DEVELOPMENT REVIEW BOARD
SUPPLEMENTAL SUBMITTAL

PROJECT NO. PR-2022-007229

Application No. SI-2022-01237

RE: Panda Express – S8-23-D20241
261 98th Street NW
Albuquerque, NM 87121
RE: DRB Planning Review – Resubmittal
DRB Project Number: 2022-007229
App. Number: SI-2022-01237

C04.0

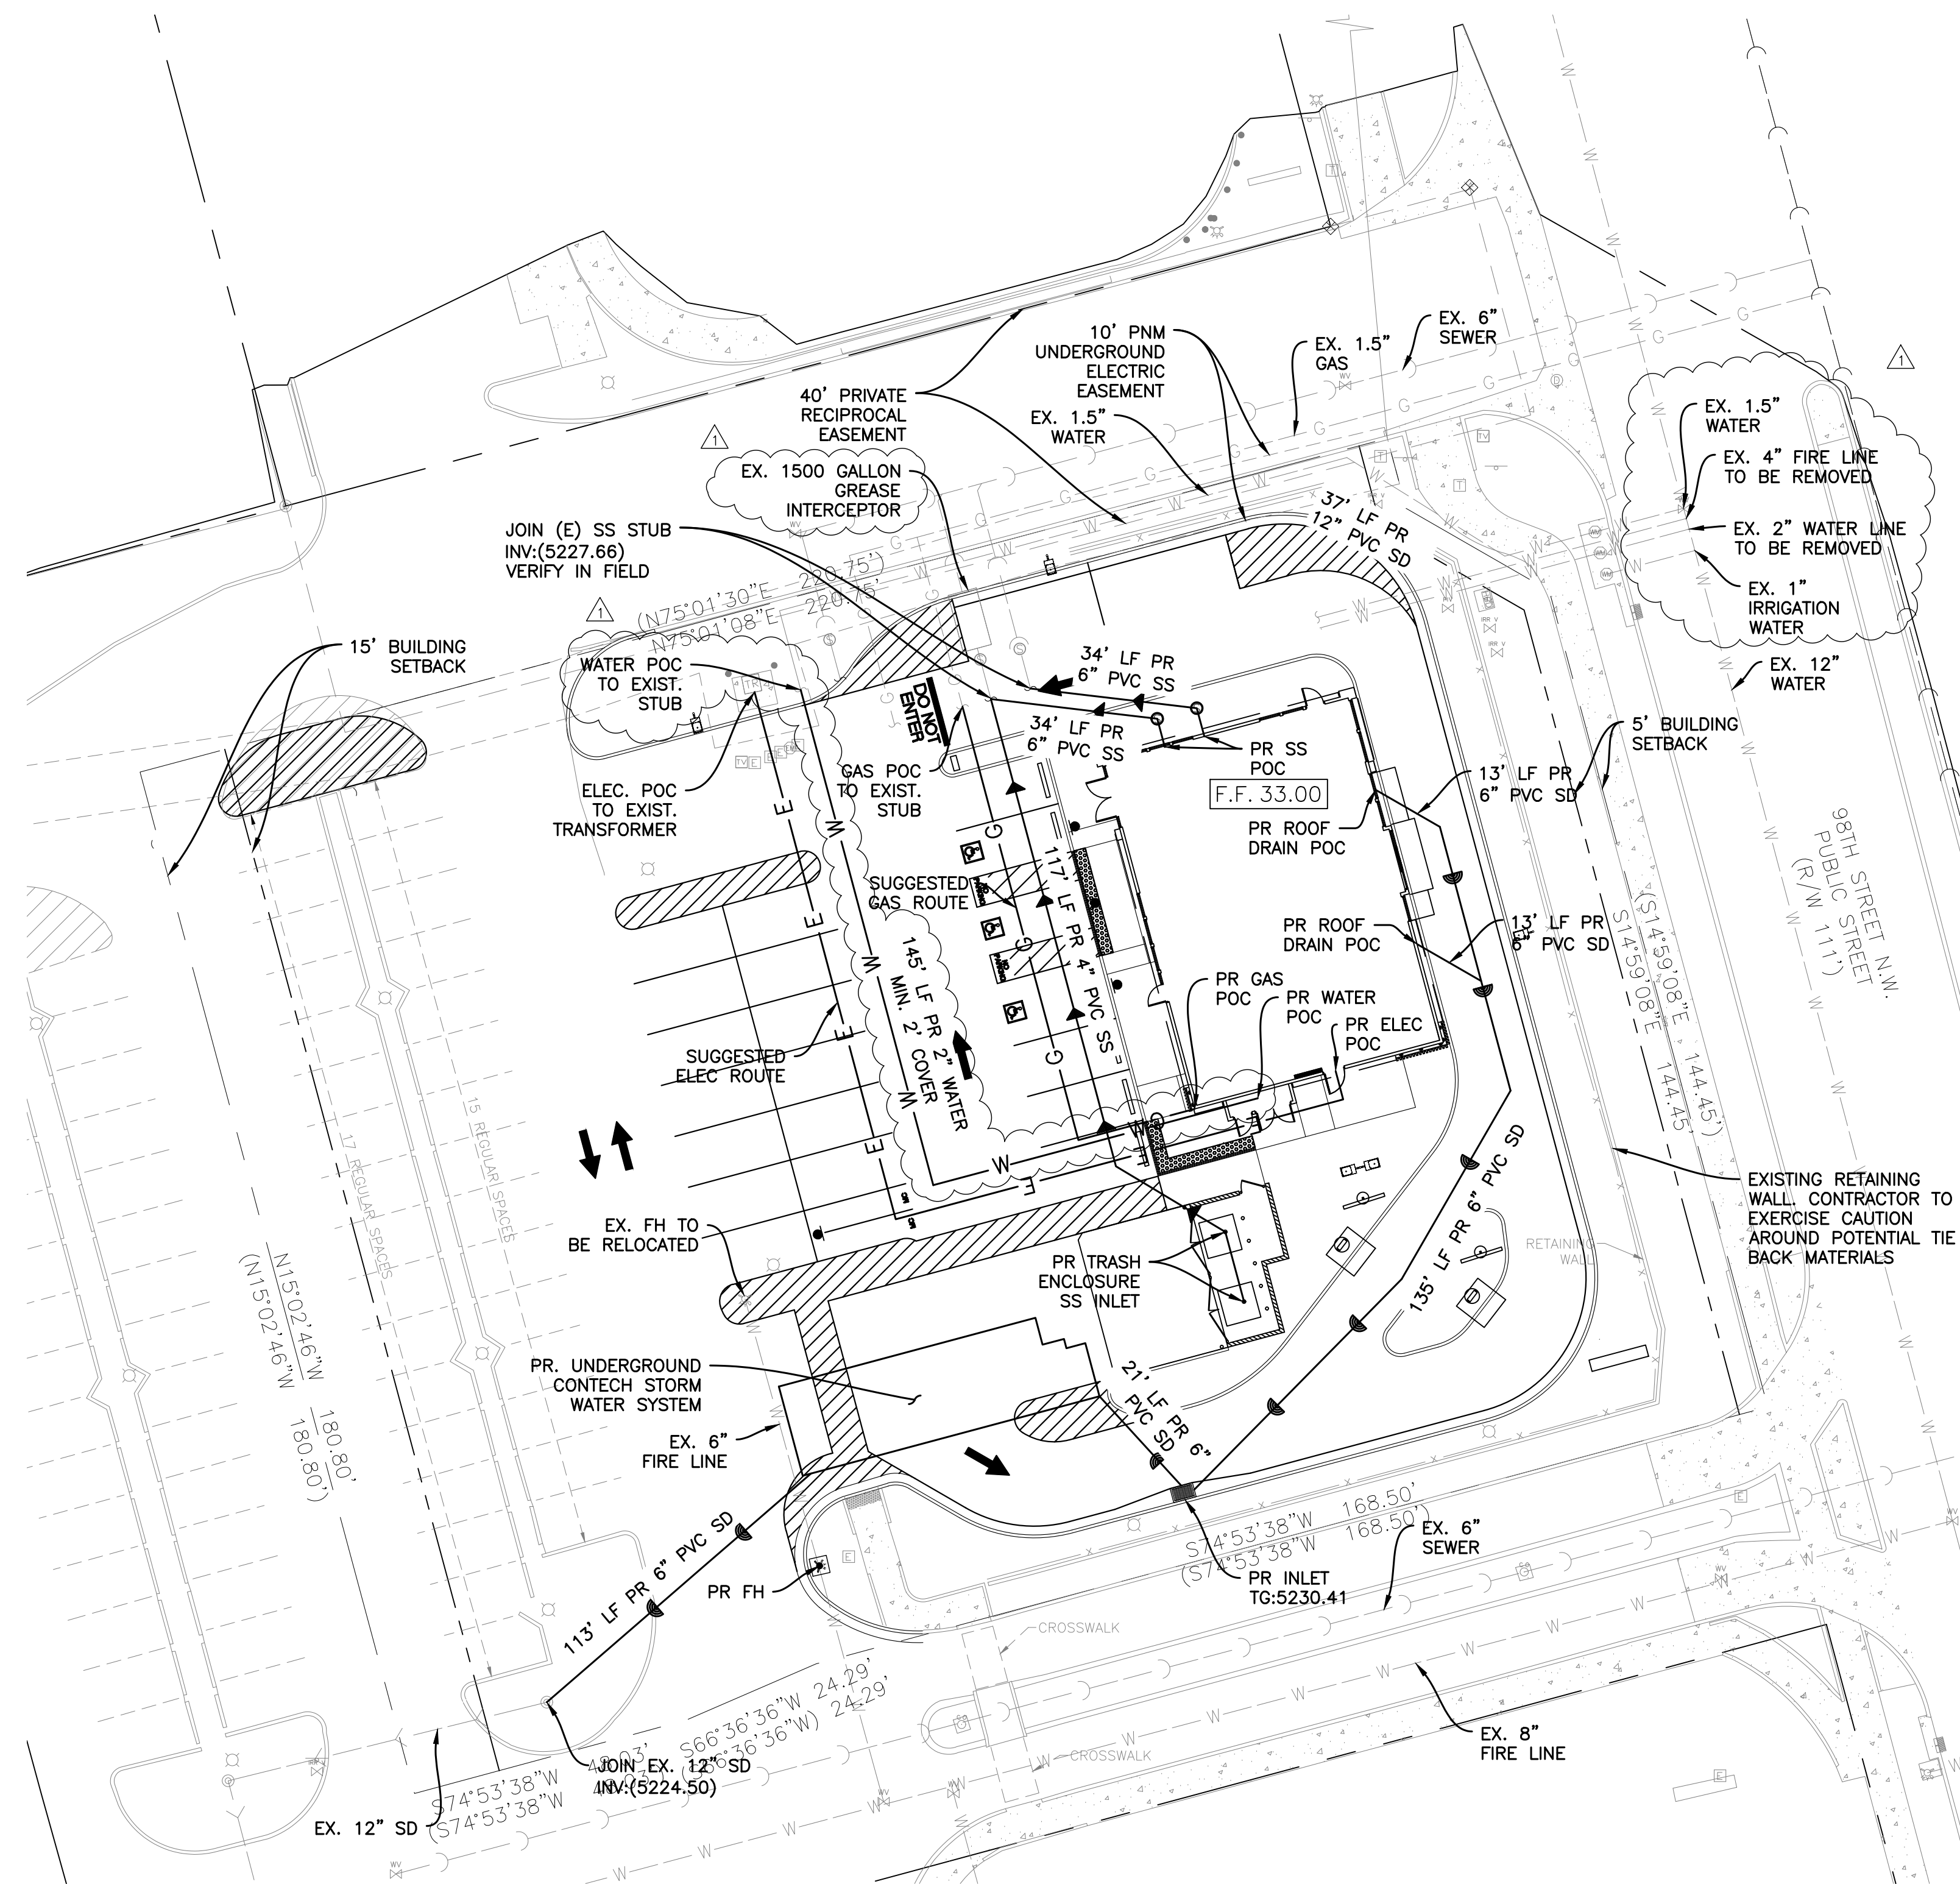
Response: Noted.
3. Pro rata is not owed for this property.
Response: Noted.
4. Utility Plan:
 - a. Label the size of the grease trap and confirm if it has been inspected by ABCWUA Pretreatment.

Response: the grease trap size, 1,500 gallons has been added to sheet C04.0. Inspection of facility will be conducted prior to start of construction.
 - b. There appears to be four service connections in the right-of-way. It appears like only one service is to be used. Unused services shall be removed and capped as a condition of service.

Response: A demolition drawing, sheet C02.0, has been added to the plan set. The existing 2-inch water service line and 4-inch fire water line will be removed. The irrigation line and water meter are in use and are called out to be protected in place.

**CPTD**  
TREES SHOULD BE MAINTAINED WITH A 6' CLEAR TRUNK. SHRUBS SHOULD BE MAINTAINED AT 3' MAX.

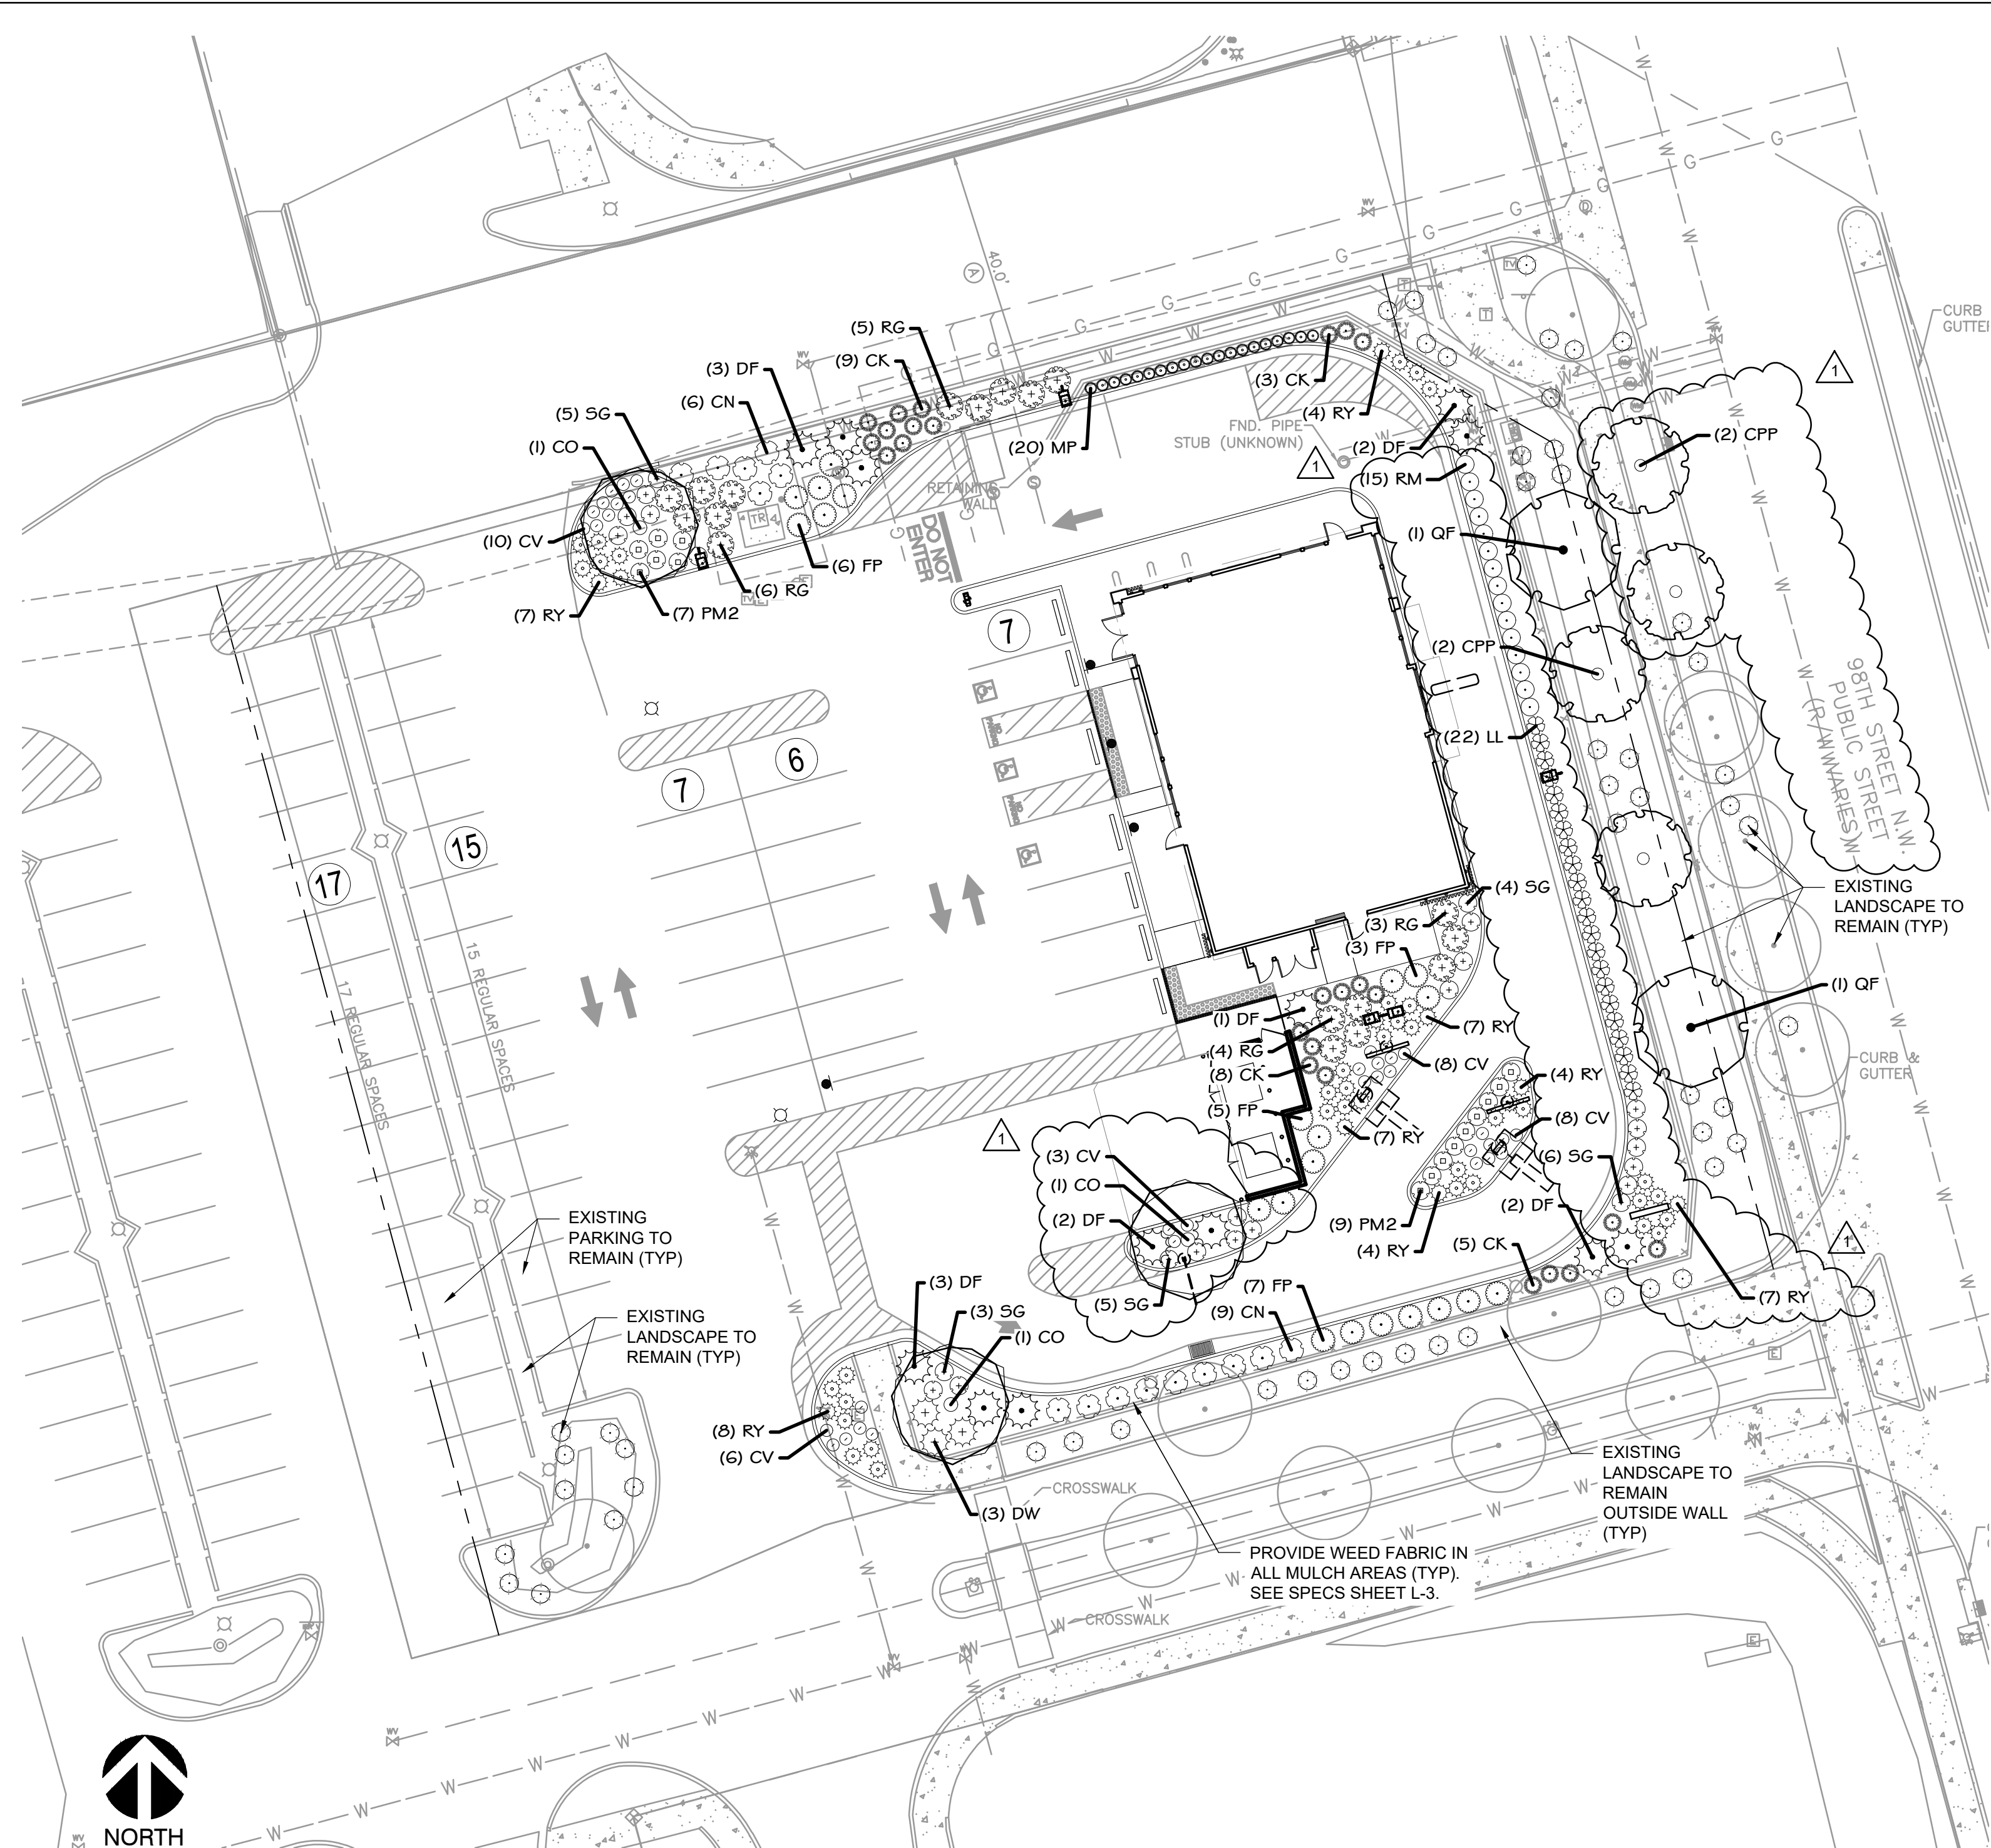
- Ensure that landscaping is maintained to provide natural surveillance, trimming trees up to create a canopy of at least six feet; and trimming shrubs and bushes down to three feet.

- Please label streets and Landscape Plan. Per IDO 5-6(D), street trees required on 98th St. NW within 20-ft from curb, spaced approximately 25-ft on center.

- 5-6(C)(5)(e) Organic mulch is required as ground cover under trees within a 5-foot radius around the tree trunk, but not directly against the trunk. In these areas, weed barrier fabric is prohibited. Please revise notes regarding mulch and tree planting detail to indicate organic mulch over tree planting area.

3. Must provide a 6-foot Landscape Buffer as per IDO 5-5(I)(2)(a) where the Drive-Through lane is adjacent to 98th Street. There must be a 3- or 4-foot wall or vegetative screen on the public street side of the buffer area, to screen the Drive-Through lane from 98th Street.

Response: *Maintenance note added to revised sheet L-1. Please reference revised planting plan, sheet L-1.*

Response: *98th street labeled on plan. Existing trees to remain satisfy street tree requirements. 2 additional trees added to fill gap larger than 25 ft. on center. Please reference revised planting plan, sheet L-1*

Response: *Note referencing organic mulch added to sheet L-1.*

Response: *A landscape shrub buffer, parallel to the D/T and 98th street is provided as indicated on the landscape plan, sheet L-1. The intent is to screen the D/T.*
